Blackcleugh, Swinhope Valley, Spartylea NE47 9UP

DESIGN AND ACCESS STATEMENT - ADDENDUM

August 2023

This Design and Access Statement Addendum should be read in conjunction with the Planning Application for alterations at the property submitted in September 2022, reference 22/03323/FUL

GARAGE & WORKSHOP
 AS PROPOSED

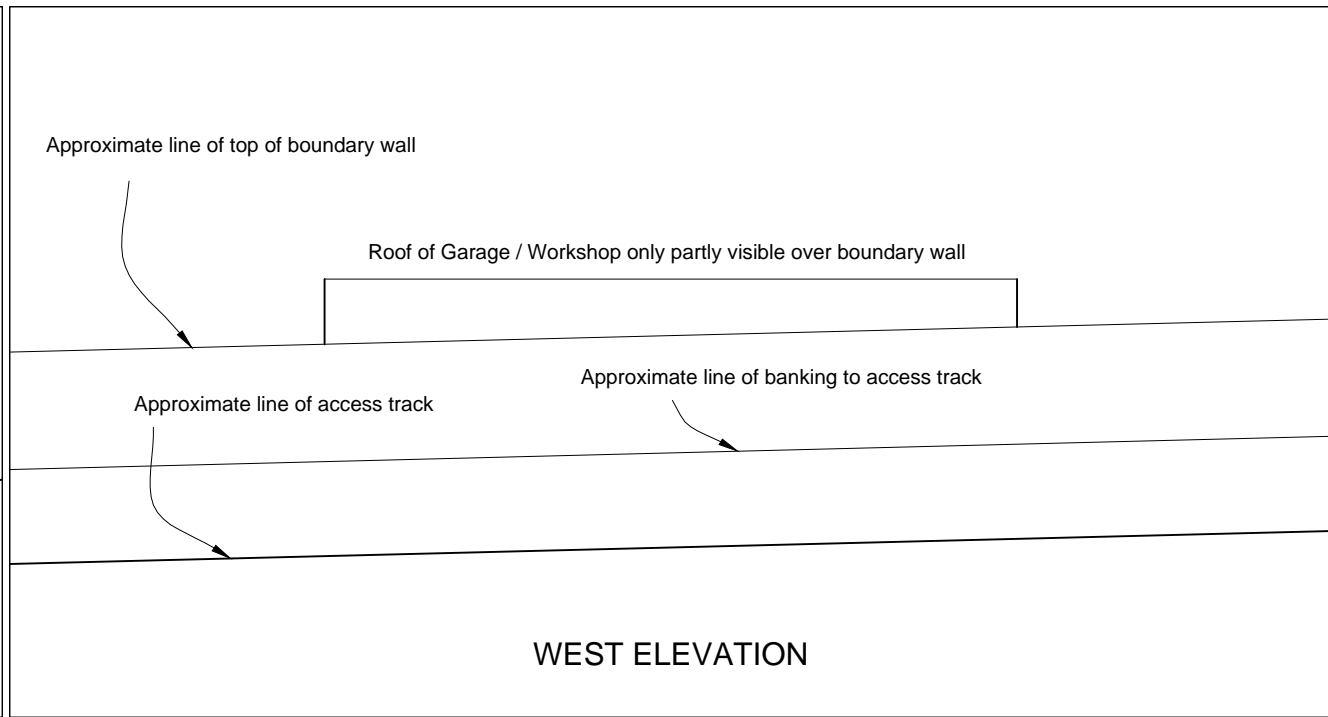
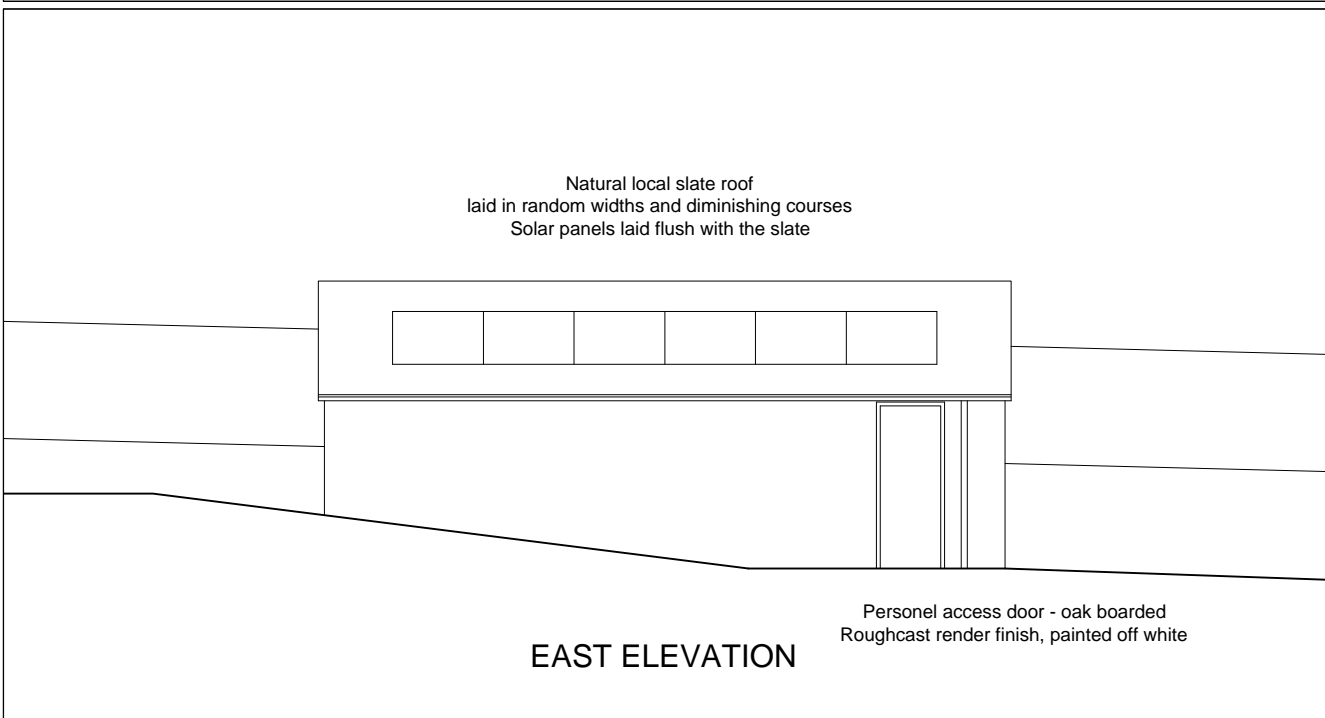
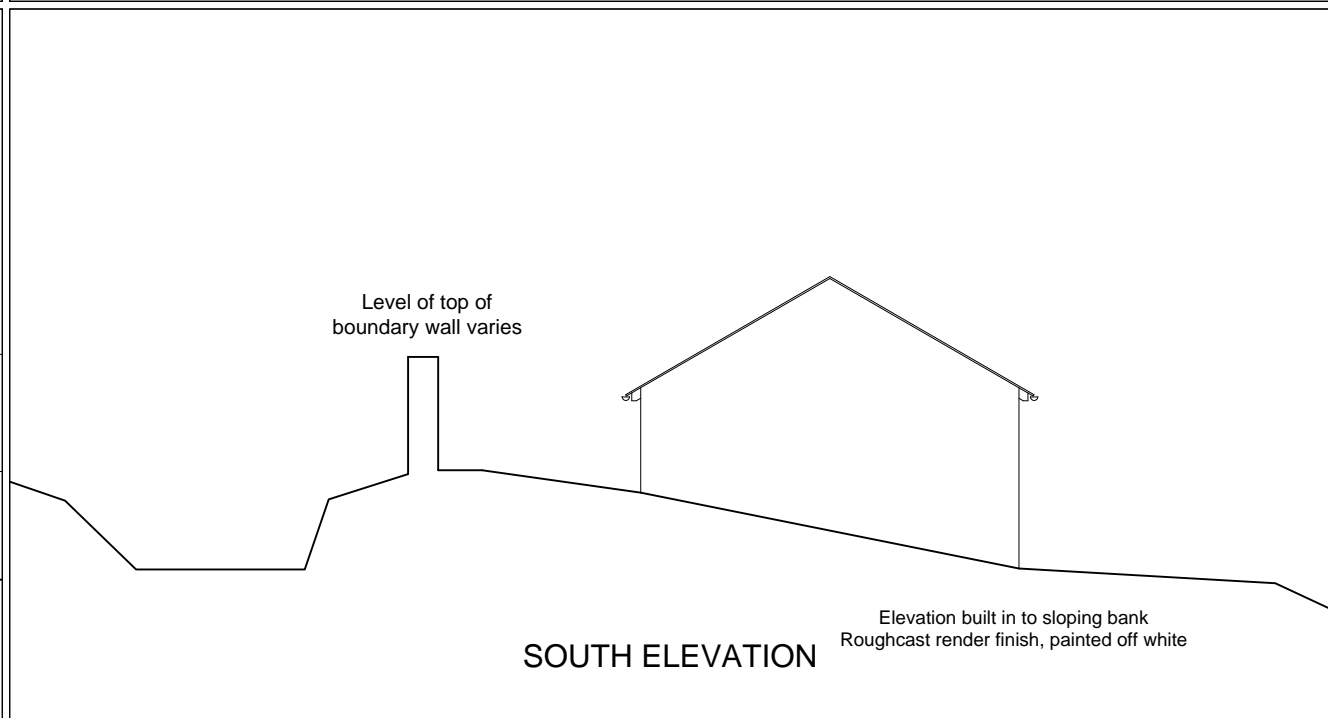
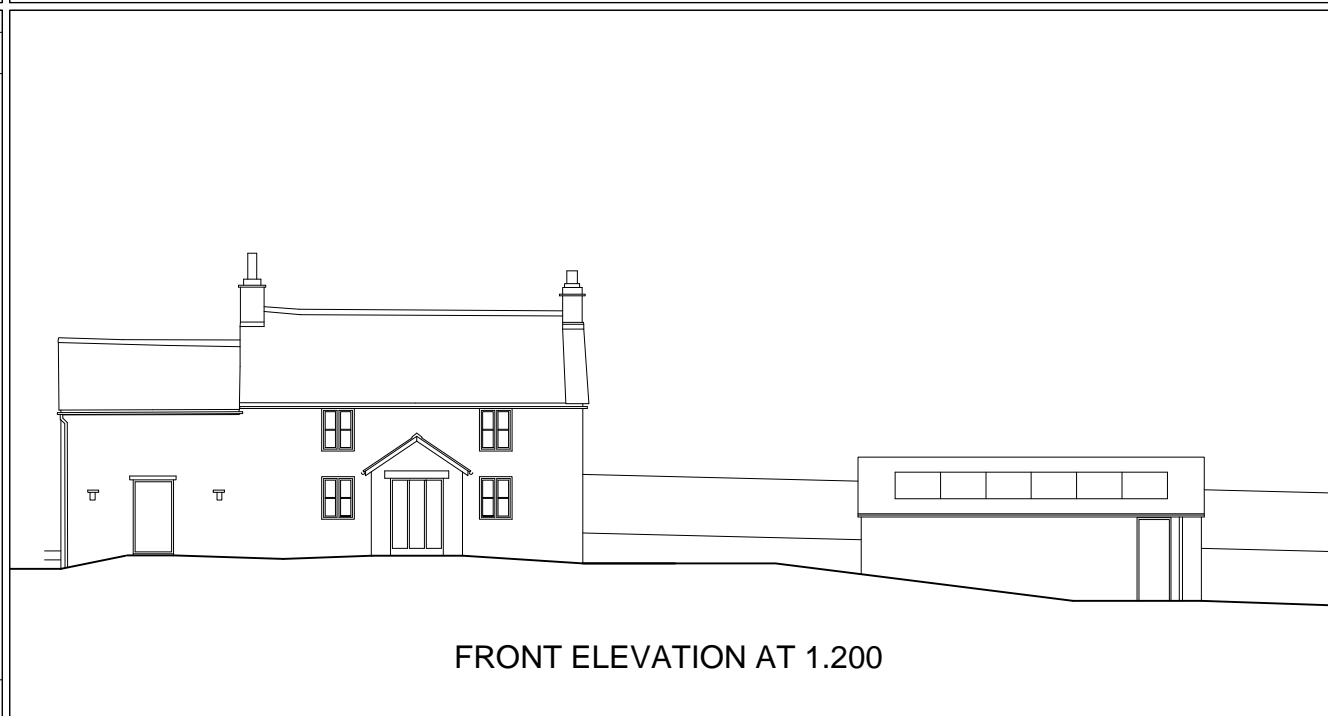
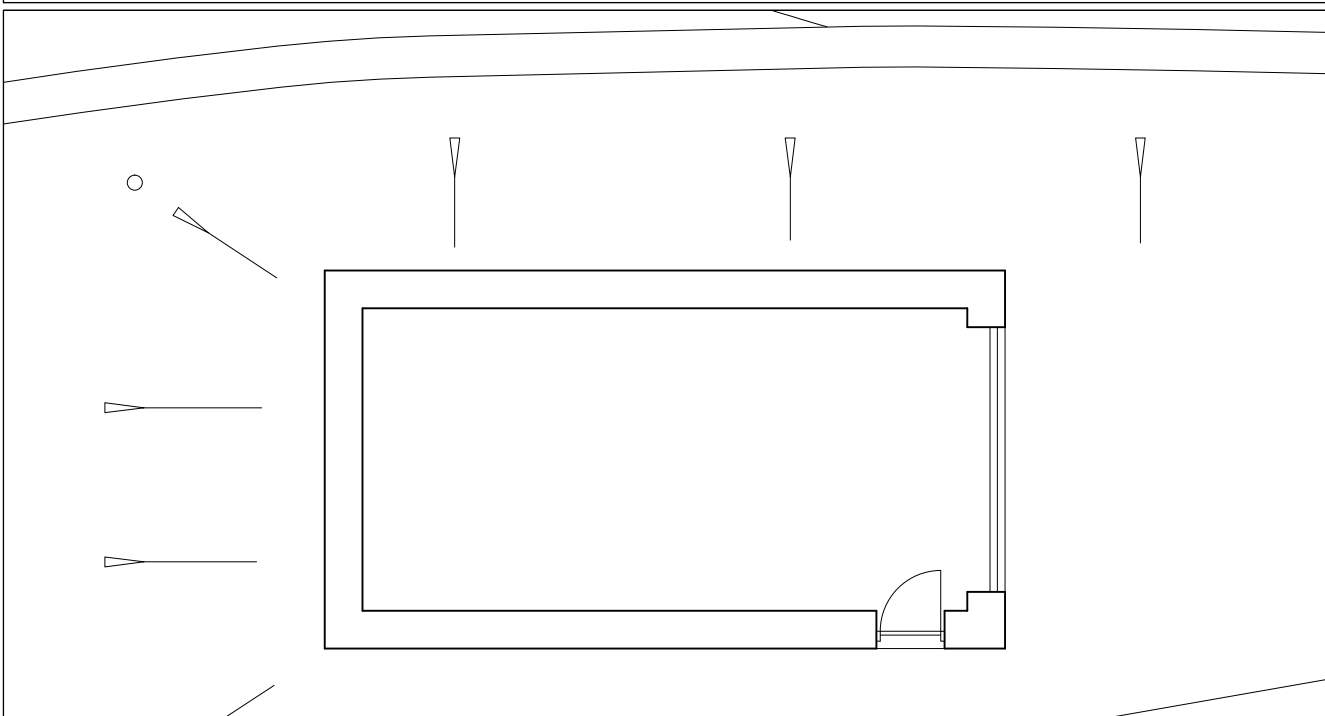
The original proposal to construct the walls of the garage and workshop in natural stone faced masonry has been reviewed and permission is now sought to finish the walls in traditional roughcast render, painted off white, in lieu of the stonework. The proposed slated roof with the integral solar panels will be retained.

The overall size and location of the garage is not altered and the building is, of necessity, substantially let into the sloping ground. Only the roof will be visible from the access track over the boundary wall. On the exposed side, the building is viewed in a wide arc from the valley below and the immediate context is the white painted masonry of the front elevation of the existing house. The fall in ground levels will mean that the garage has an obviously subservient relationship to the house itself. The use of traditional roughcast render is appropriate for a utilitarian building of this nature and we feel that the change will not adversely affect the overall appearance of the proposals.

ELEVATIONS
AS PROPOSED

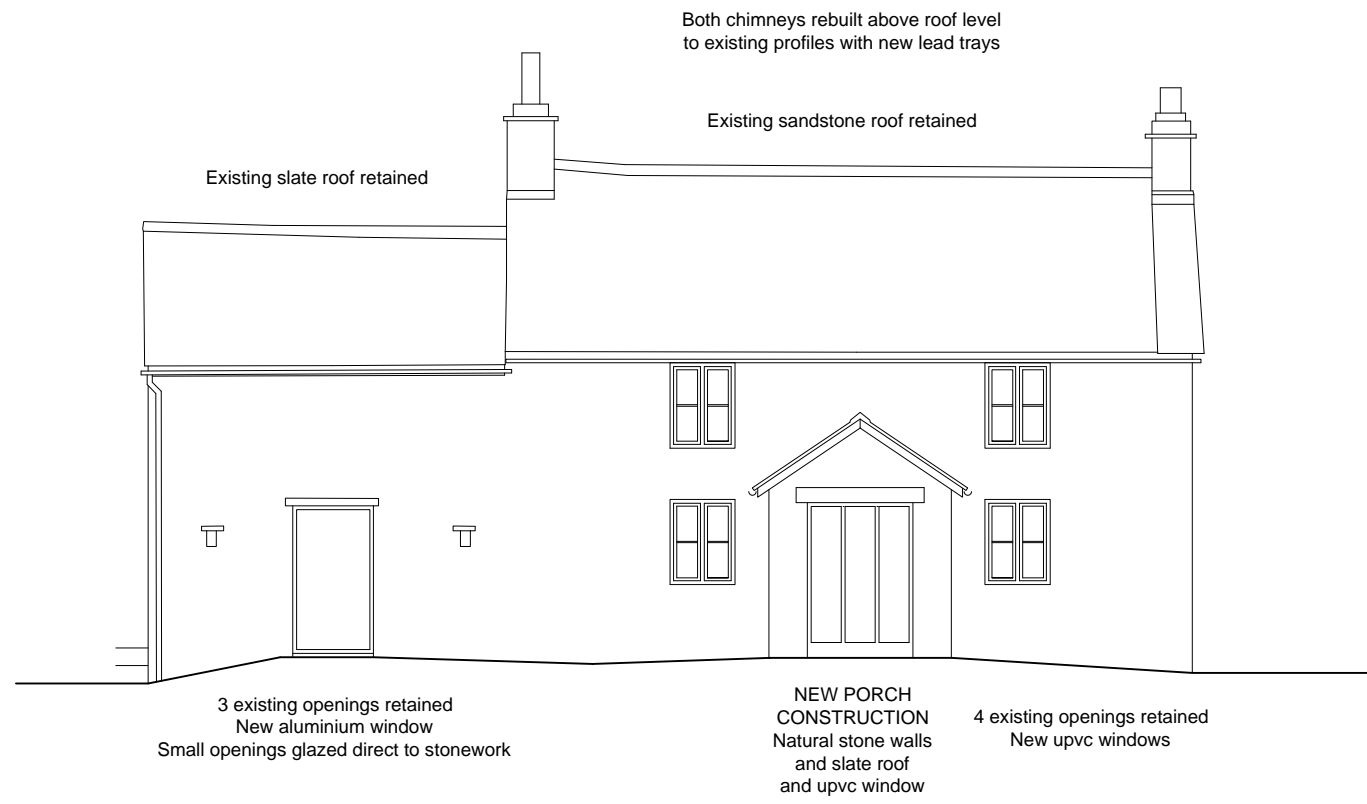
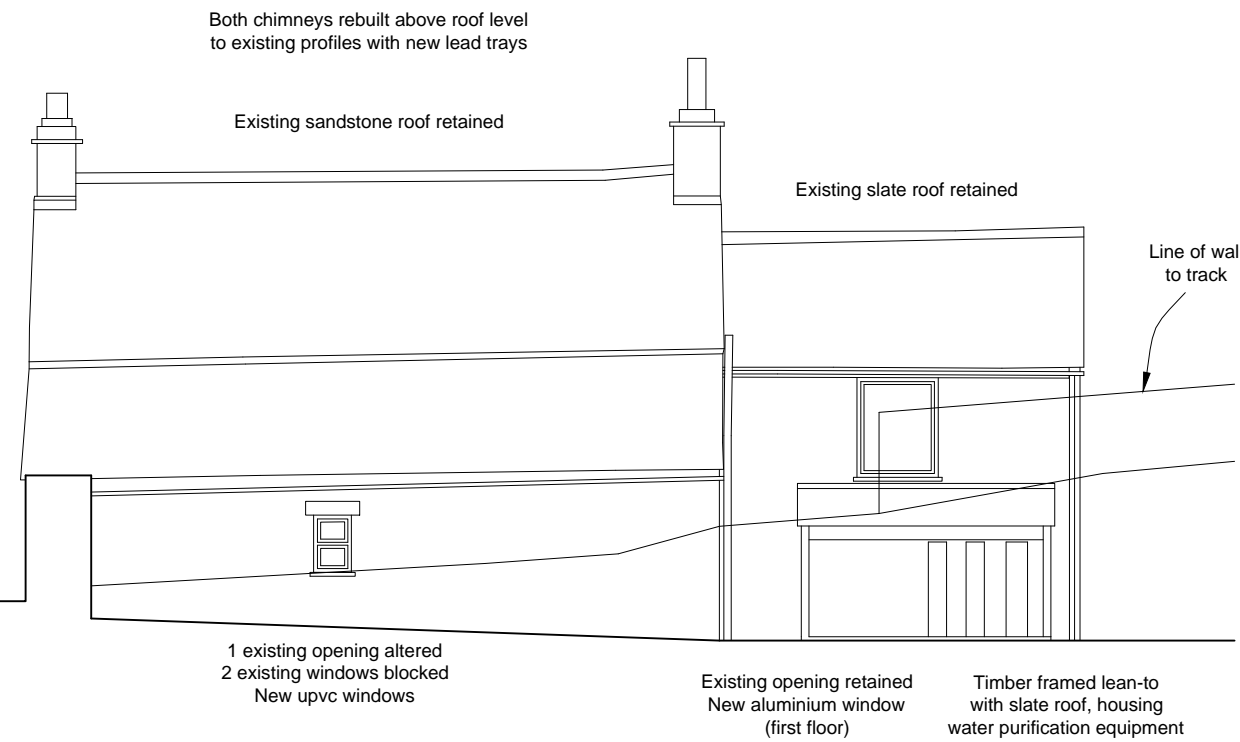
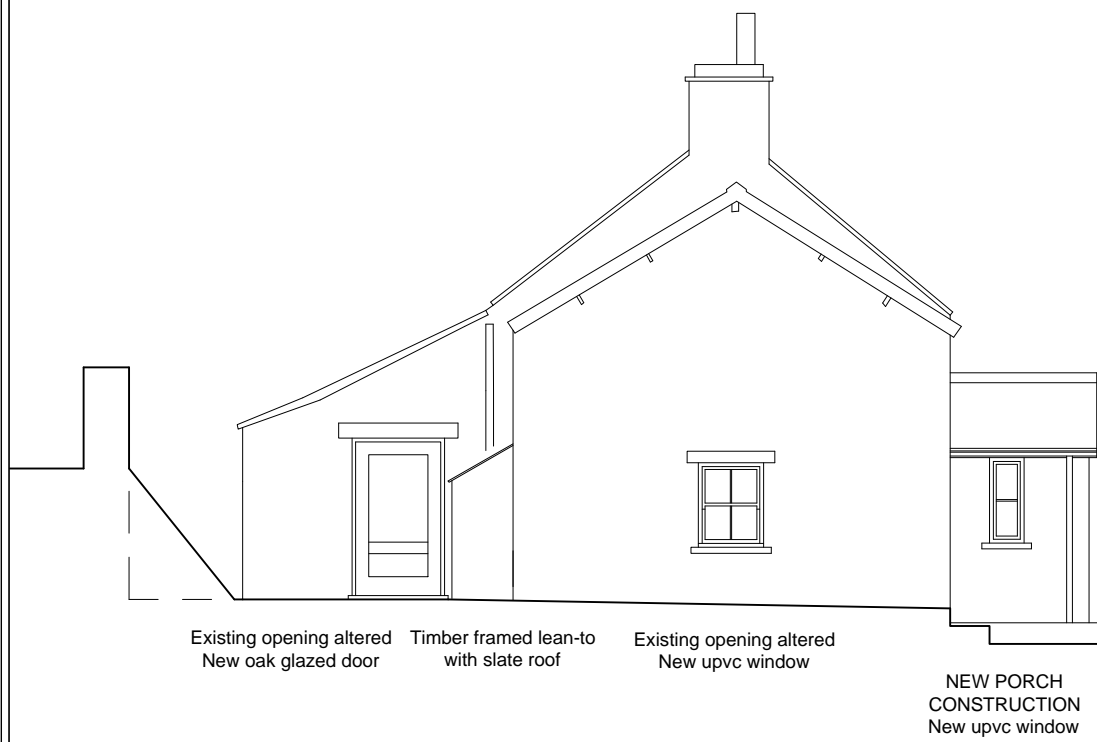
Some of the window and door details have been altered slightly as regards the arrangement of opening and fixed lights but the overall opening sizes have not changed. The materials and general specification remain largely the same – ie UPVC casements, finished white. In the case of the doors that are converted to windows in the barn extension, these have been altered to dark coloured aluminium.

One window at first floor level on the south elevation and one window at ground floor level on the west elevation have been omitted.
